Recommendation Report for Planning Permission for Works or Extension to a Dwelling

REF NO: FP/257/18/HH

LOCATION: 16 Vicarage Lane
Felpham
PO22 7DZ

PROPOSAL: Alterations to form new 2nd floor with front & rear dormer projections - Resubmission of FP/104/18/HH. This application affects the setting of a Grade 2 Listed Building

sheet 3b of 6

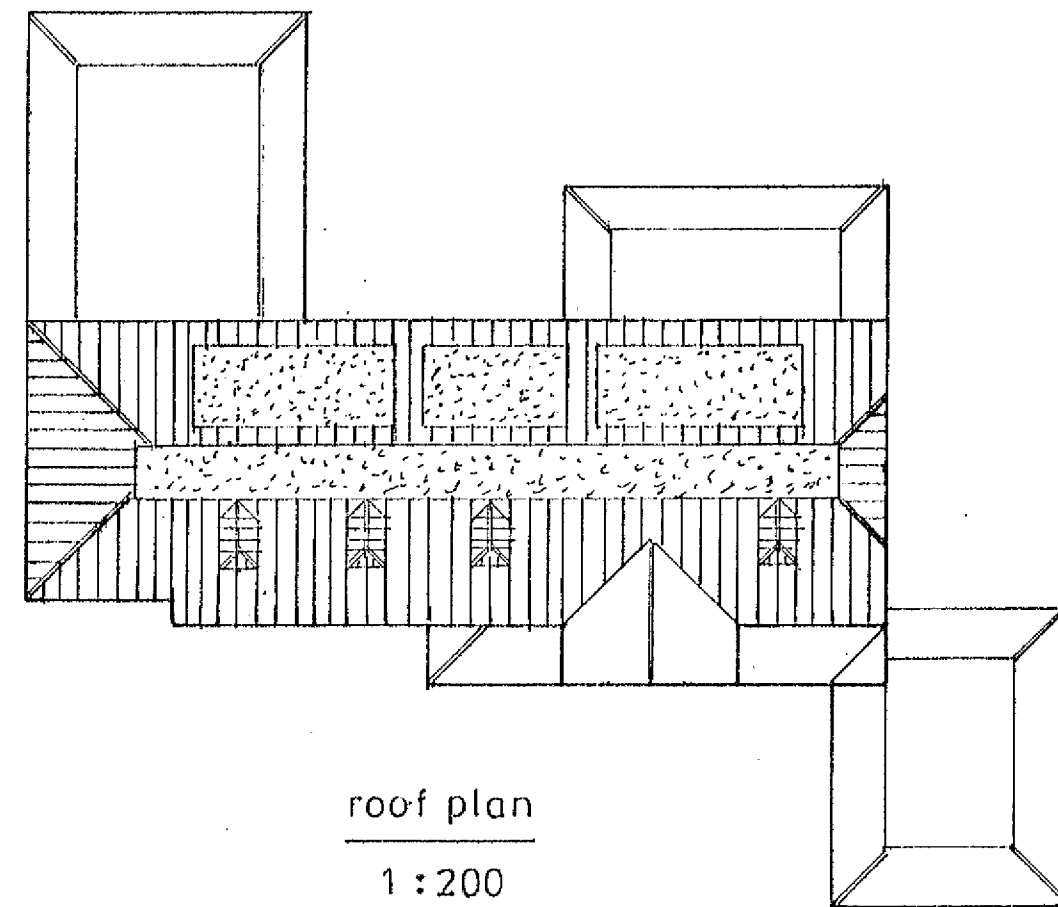
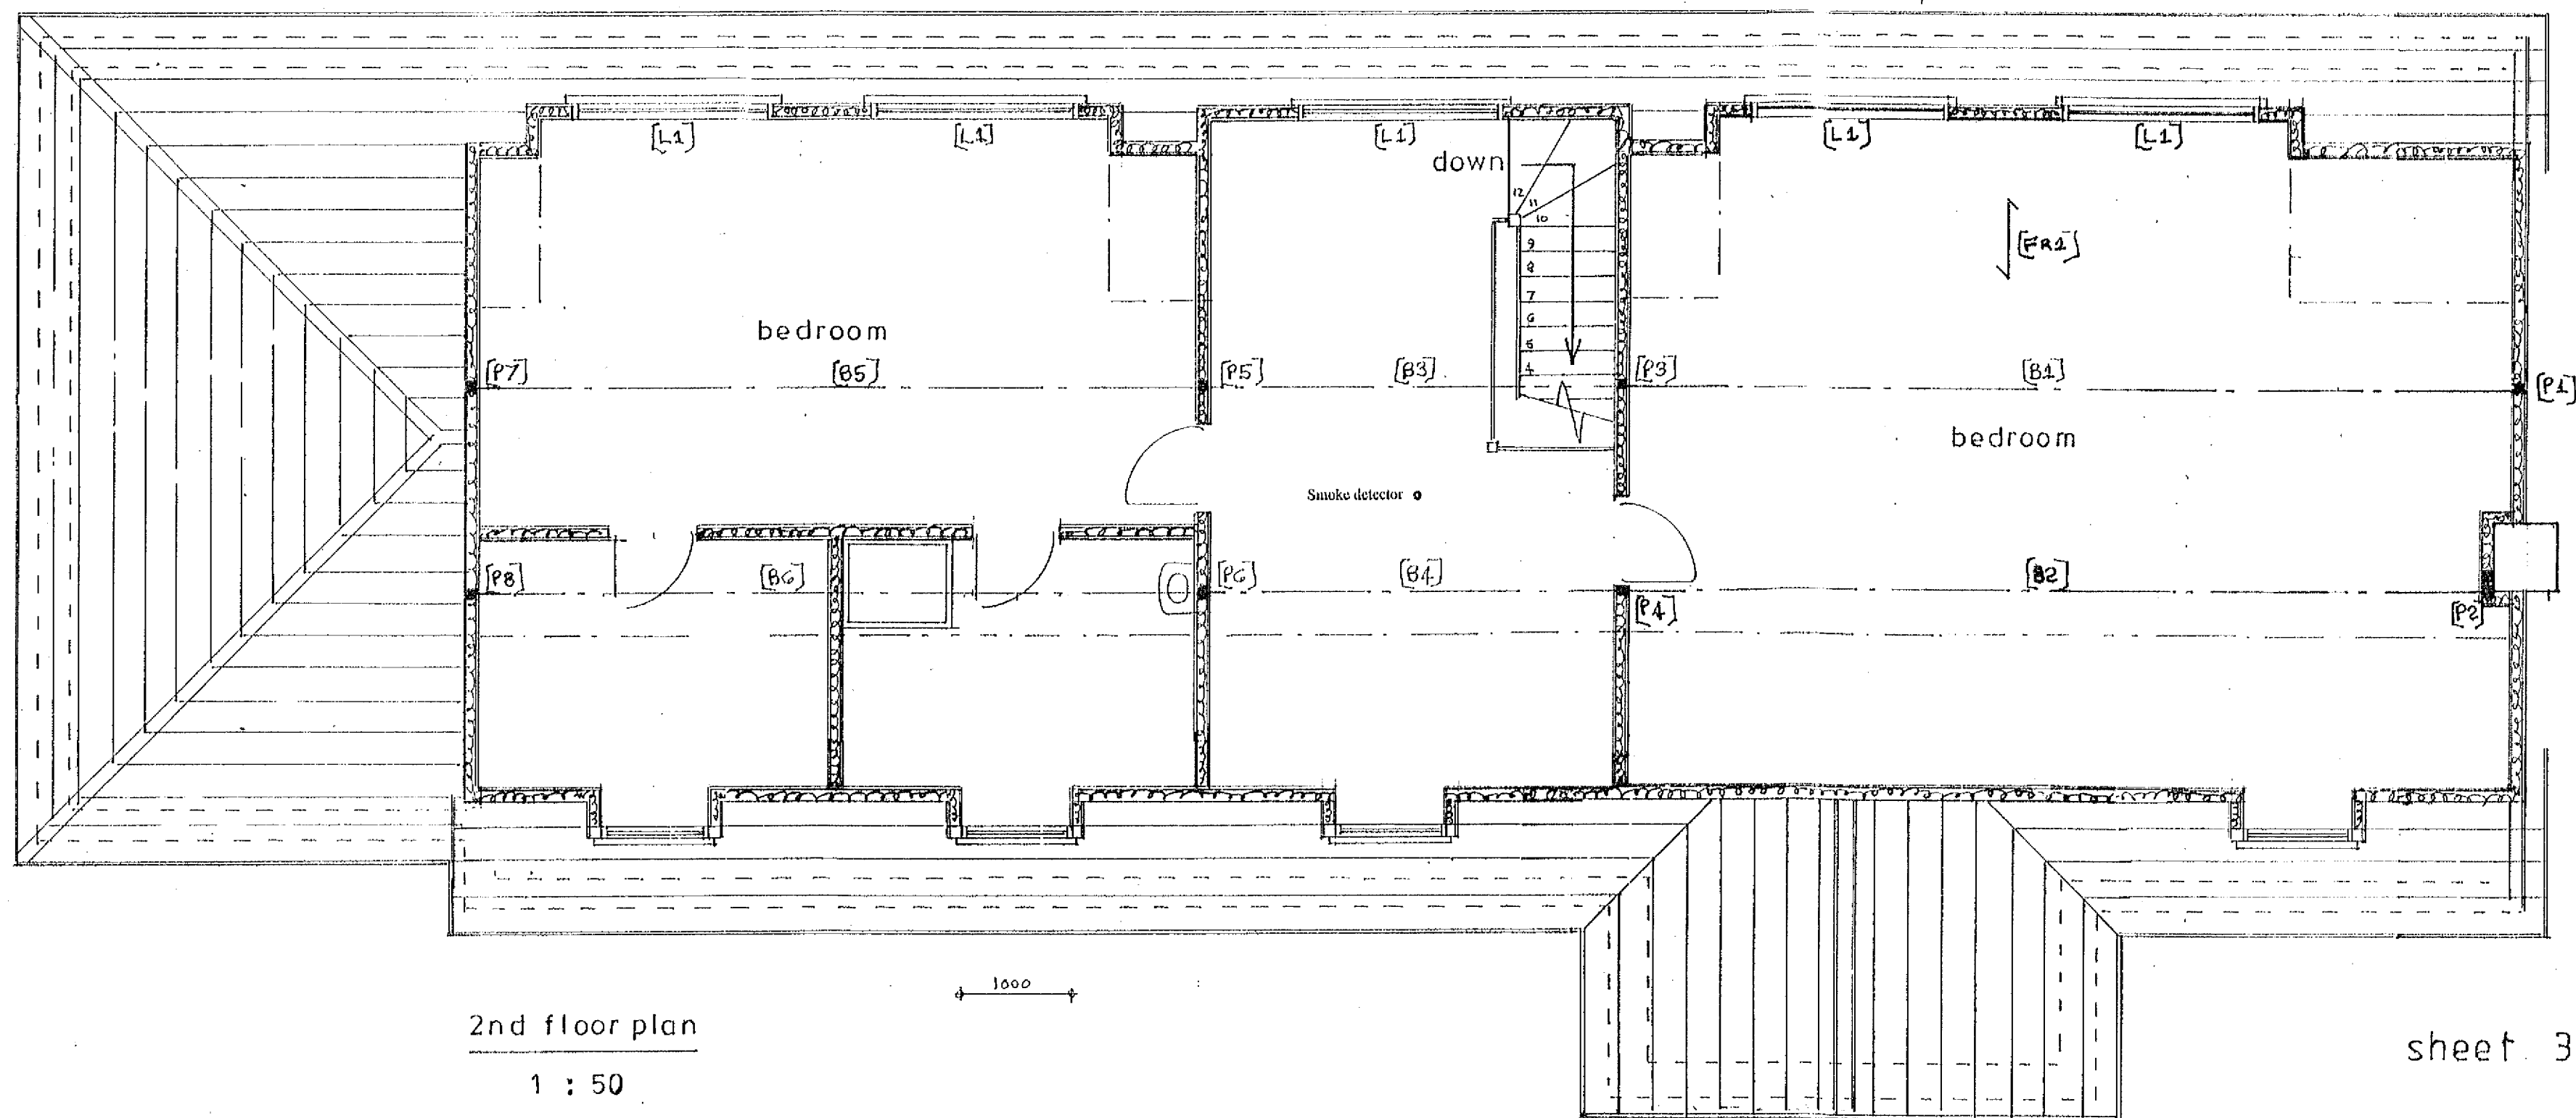
It is not considered that the extensions are subservient to the main building but the majority have been approved with the exception of the front dormers. The front dormers, by reason of their number, size and position of the dormers, will cause harm to the character of the area

sheet 4 b of 6

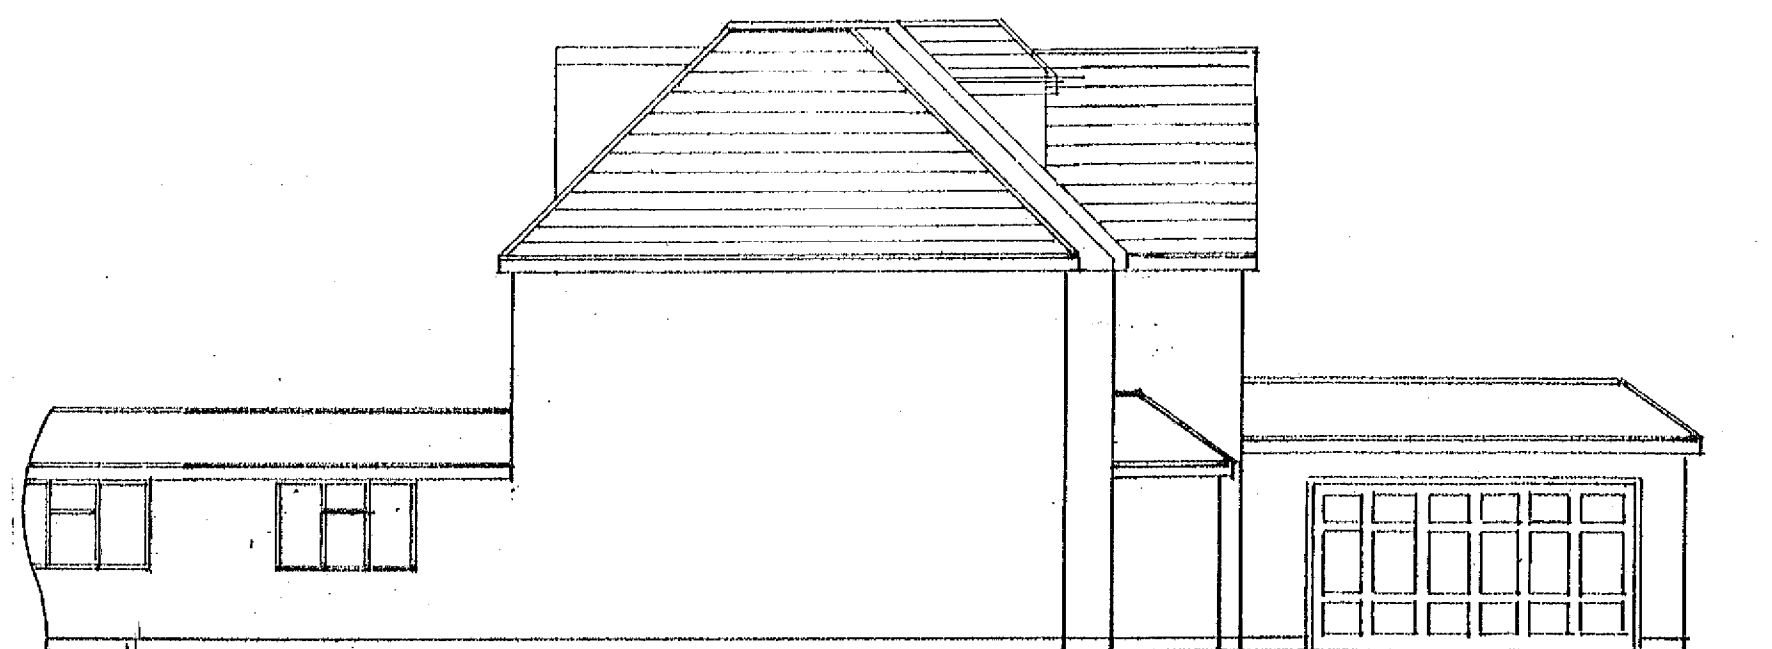
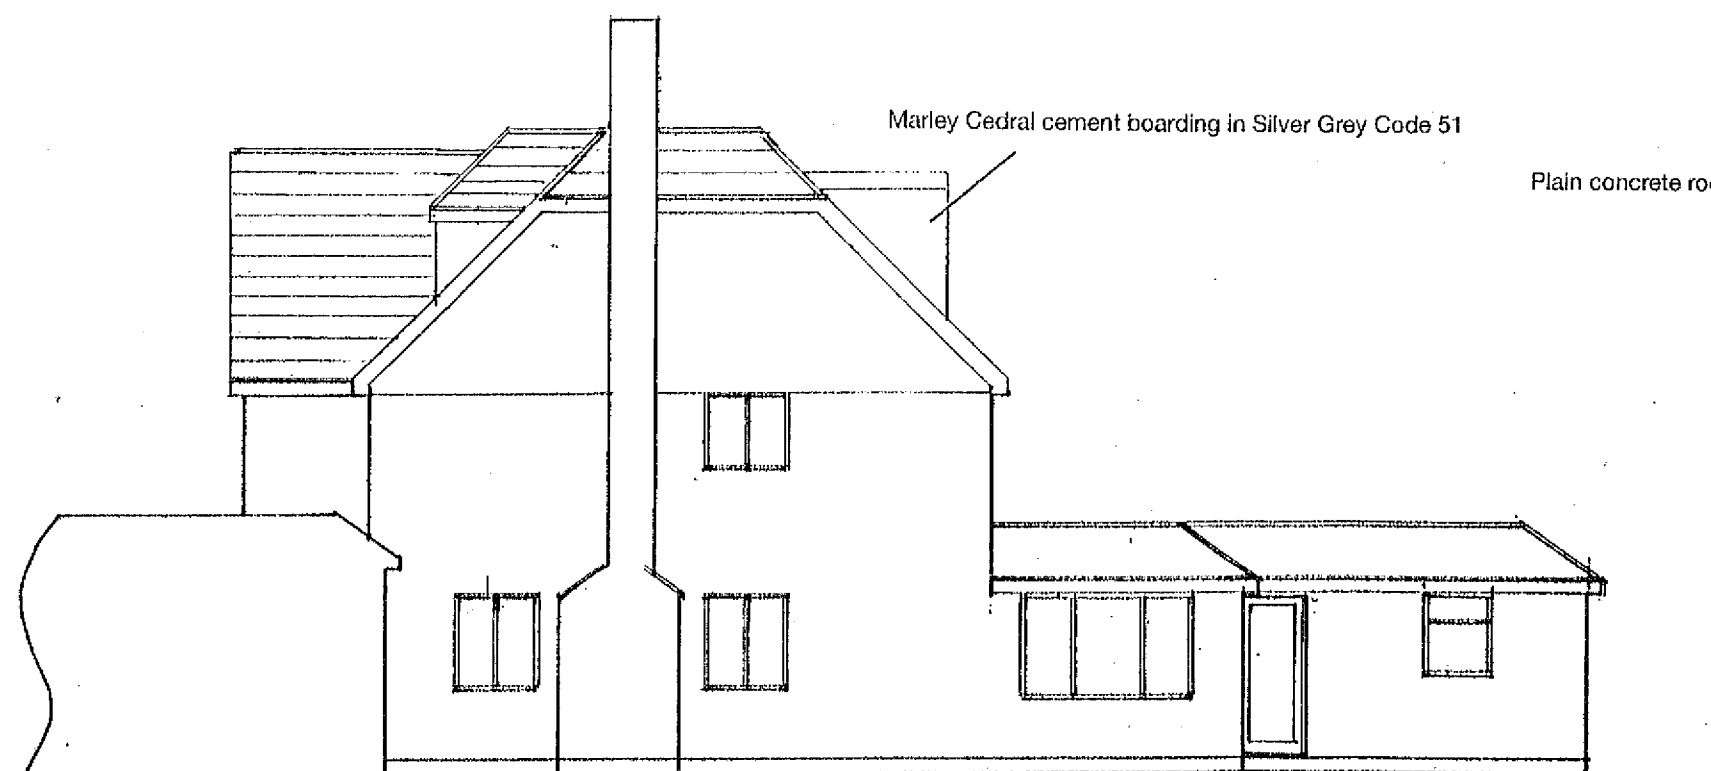
The property subject to this application is already raised from the road surface, and is fairly dominant in the street-scene. It is considered that addition of the front dormers and the raising of the roof height would result in a dominating impact on the street scene.

It is not considered that the front dormers give rise to any harmful overlooking given that these serve non principal rooms and that the residential properties opposite are over 20m away. The rear dormers windows face south and the nearest residential property is 29m away. There will be some loss of light to the windows on the western flank wall of no. 15 but these are non principal windows and although the roof on this side will be higher it remains as a hip and therefore slopes away from that dwelling.

- 1 The addition of dormer windows to the front of the dwelling by reason of their size, number and appearance would cause less than substantial harm on the setting of adjacent heritage assets (designated conservation area and listed building). However in the absence of a heritage statement and any public benefits arising from the scheme the proposal is contrary to the NPPF, policies HER DM1 and HER DM3 of the Arun Local Plan and Felpham Neighbourhood Plan Policy ESD7.

- 2 The front dormer windows by reason of their size, number and appearance would cause harm to the character and appearance of the area contrary to policies D DM1 and D DM4 of the Arun Local Plan and ESD1 of the Felpham Neighbourhood Plan.
